WEST SUSSEX COUNTY COUNCIL CONSULTATION

TO:	Arun District Council FAO: Z Toppin
FROM:	WSCC - Highways Authority
DATE:	2 March 2021
LOCATION:	28 Ash Lane Rustington BN16 3BT
SUBJECT:	R/19/21/HH Installation of a 3m wide drop kerb to enable off road parking.
DATE OF SITE VISIT:	n/a
RECOMMENDATION:	Advice
S106 CONTRIBUTION TOTAL:	n/a

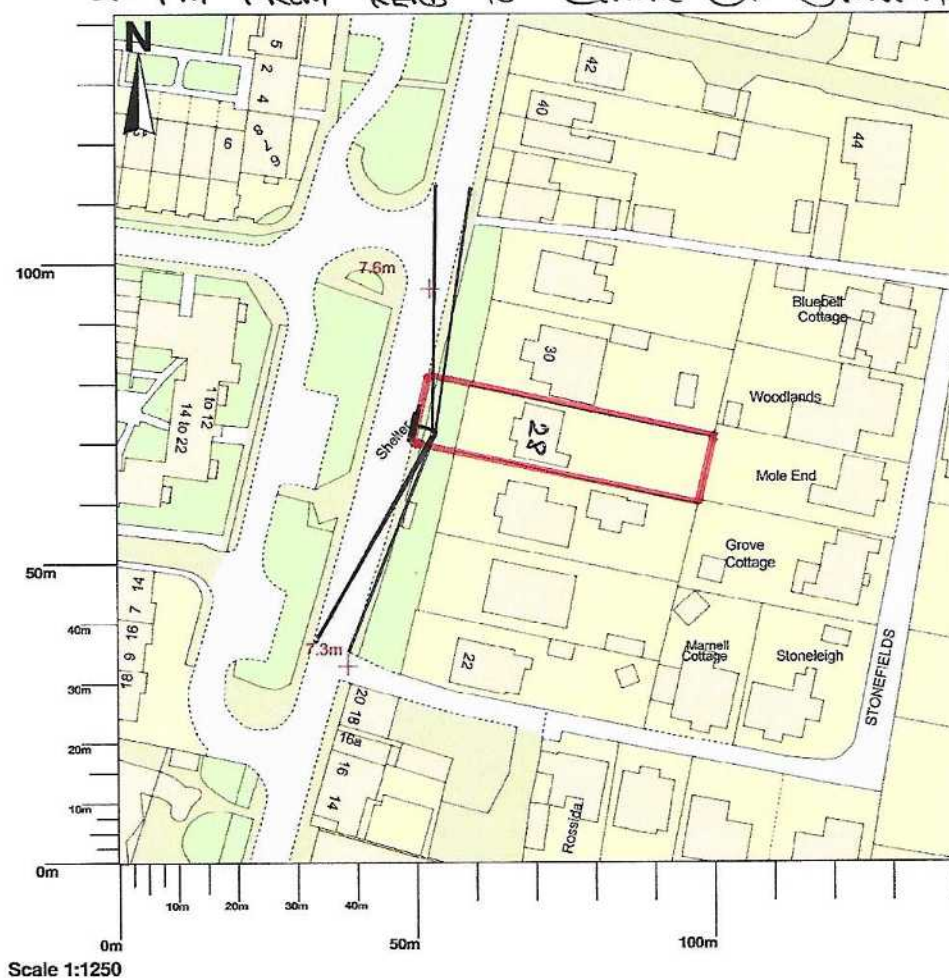
The proposed plans demonstrate that the vehicle crossover (VCO) will be 3m wide. SPlays have been demonstrated by the applicant, but the lenth (Y distance) of these splays have not been annotated on the plans, An inspection of WSCC mapping indicates that splays of in excess of the required 2.4 x 43m are achievable in this location. The splays fall wholly within the highway boundary and do not appear to be impacted by the large highway sign to the immediate north.

The applicant has not demonstrated the proposed parking provision, however there appears to be sufficient space for vehicles to park and turn on site, enabling vehicles to exit in a forward gear. Details of parking can be secured via condition.

The use of the car parking spaces shall not commence until such time as the vehicular access has been constructed in accordance with the details shown on the drawing titled Block Plan with Corssover.

The use of the access shall not commence until such time as the parking area has been constructed in accordance with plans and details to be submitted to and approved in writing by the Local Planning Authority. These spaces shall thereafter be retained at all times for their designated purpose.
